**From:** [REDACTED]  
**Sent:** 13 March 2019 09:55  
**To:** Planning.Responses  
**Subject:** RE: Planning Consultation on: Y/4/19/RES

**App No:** Y/4/19/RES

**Address:** Cinders Lane Nursery & works to R/O Cinders Lane  
Yapton BN18 0JJ

**Proposal:** Approval of reserved matters following outline consent  
Y/5/17/OUT for 51 No. dwellings. This application affects  
a Public Right of Way.

Tree protection plan
Location of trees, categorisation & protection/management proposals at Cinders Lane, Yapton, Arundel

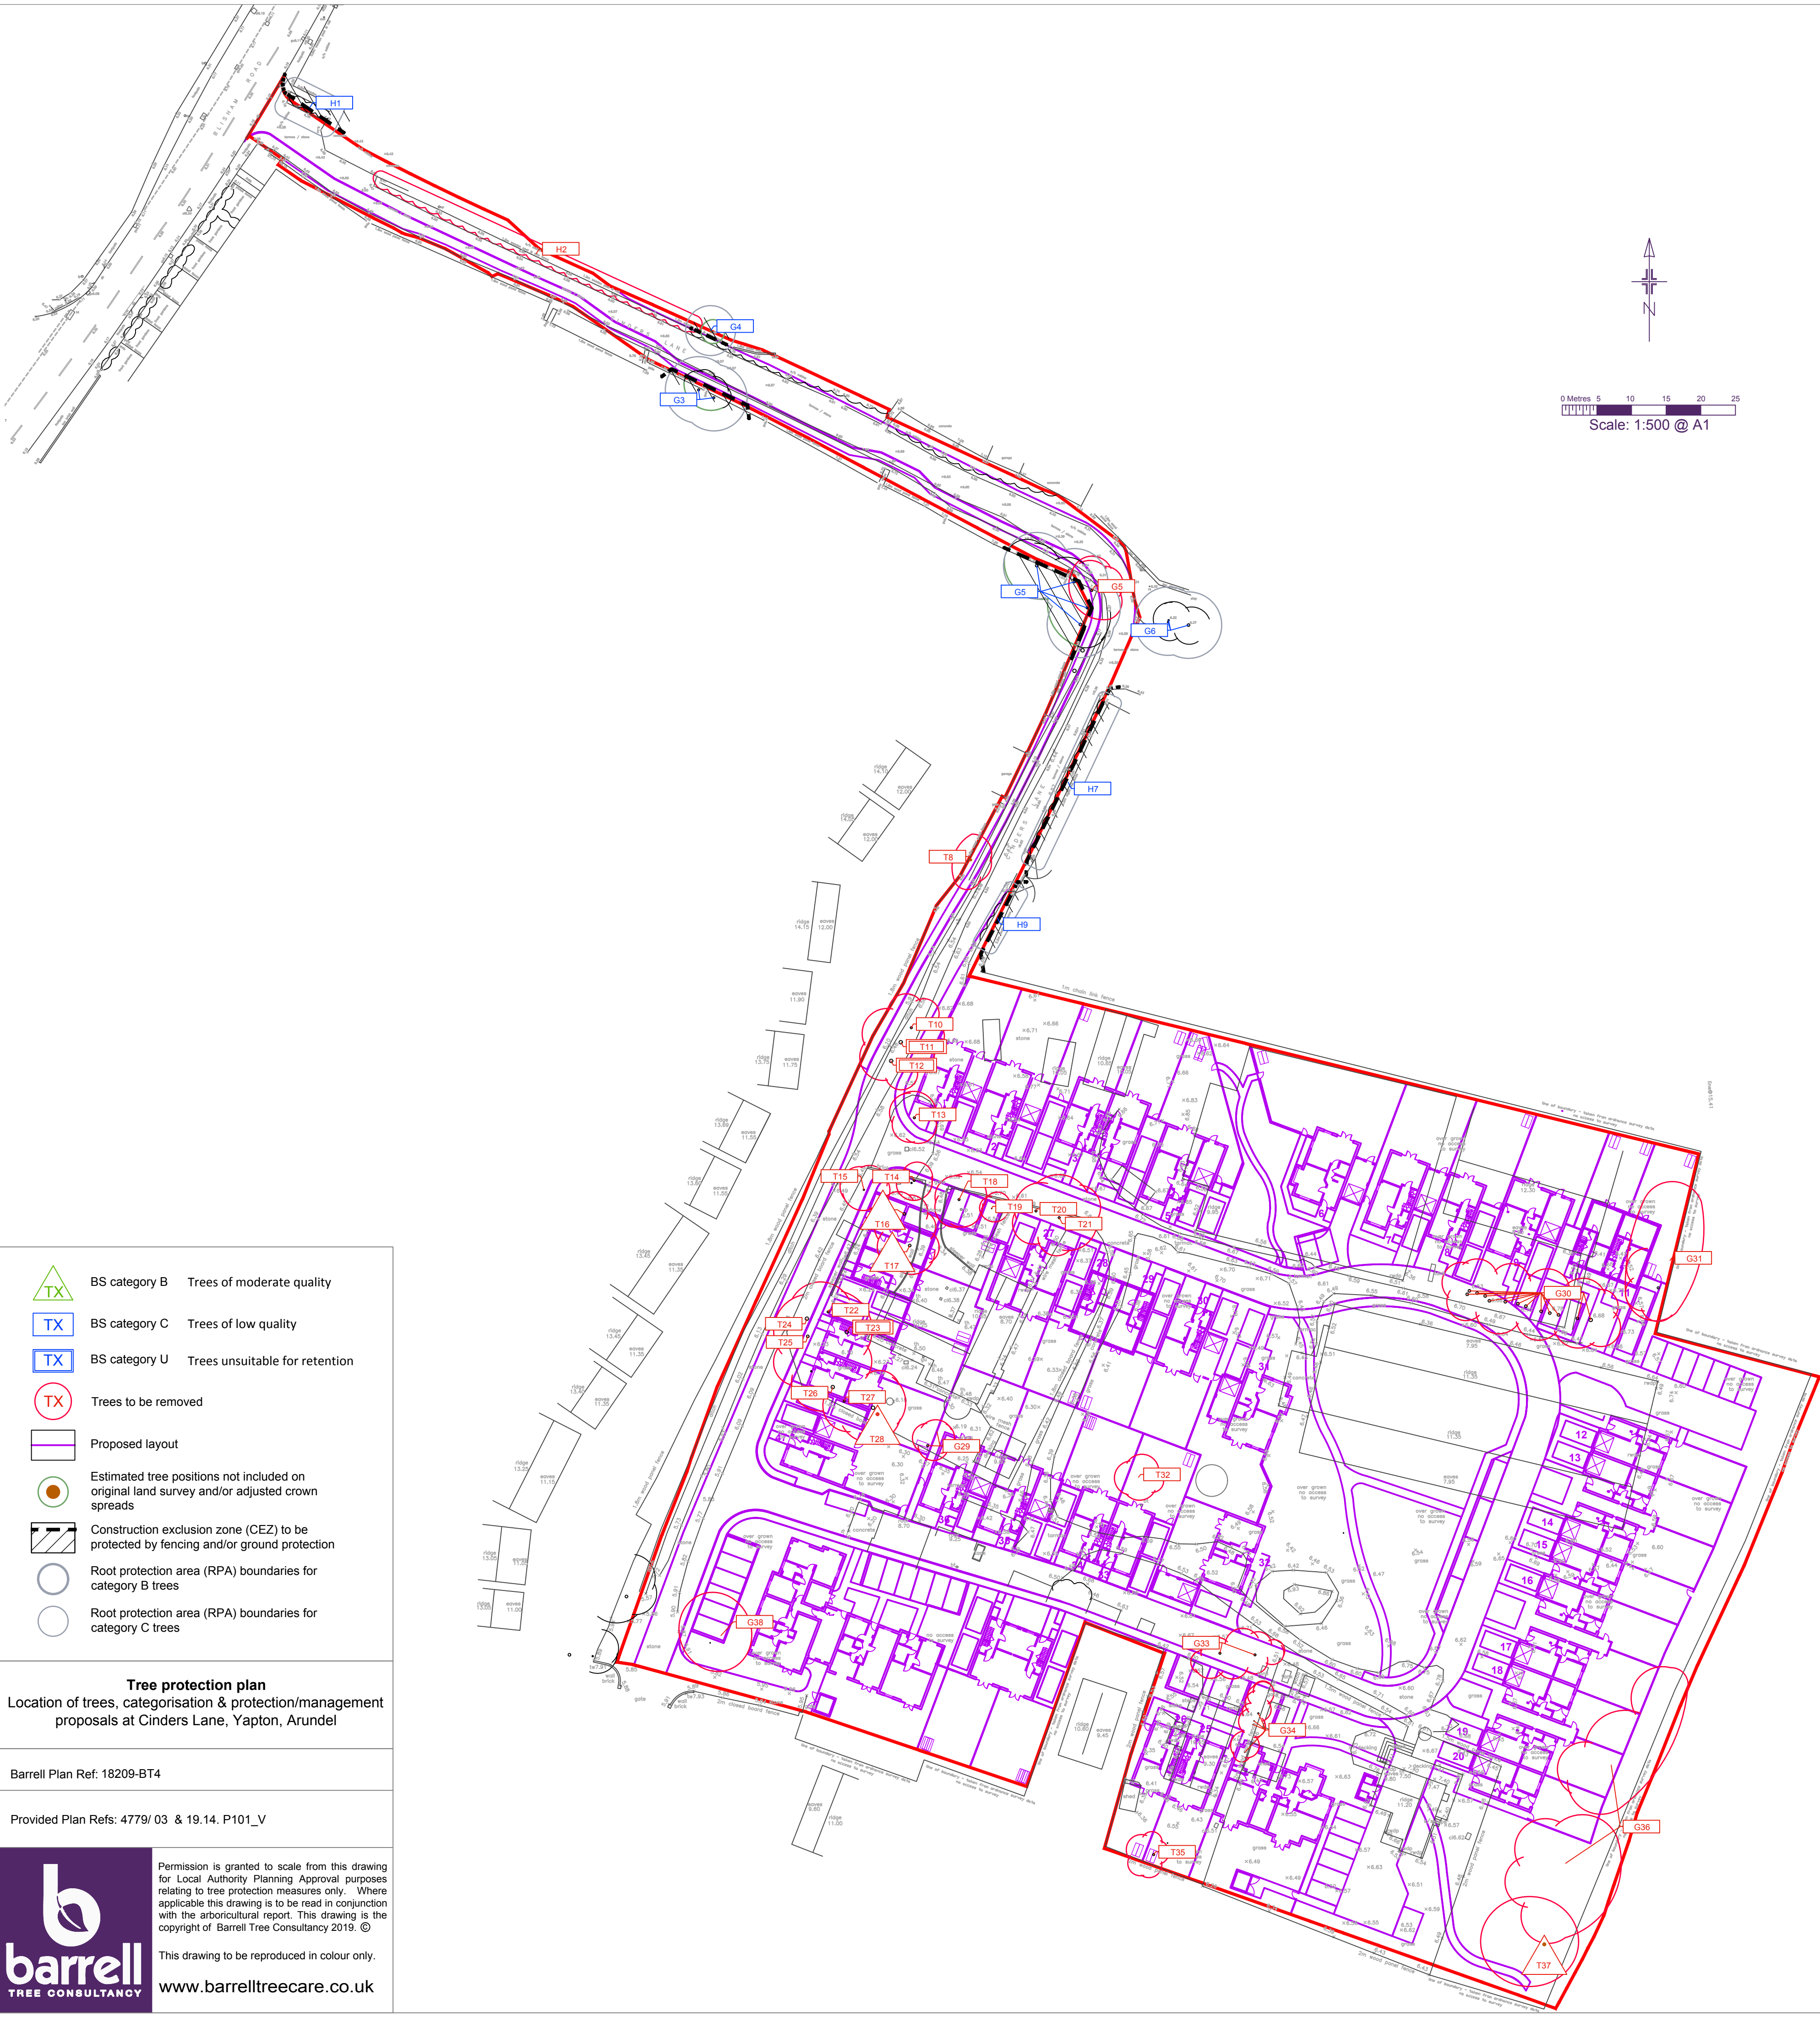
The hedgerows on site are used by bats for commuting and foraging and will need to be retained and enhanced for bats. This will include having a buffer strip around the hedgerows (5m) and during construction fencing should be used to ensure this area is undisturbed. Any gaps should also be filled in using native hedge species to improve connectivity. Where any hedge is to be removed at detailed within the survey, new hedgerow should be planted.

- Bat roosting opportunities within the building framework using bat tiles, and bricks
- Any trees removed should be replaced at a ratio of 2:1
- Filling any gaps in tree lines or hedgerows with native species
- Bat and bird boxes installed on the site
- Wild flower meadow areas within the open space onsite
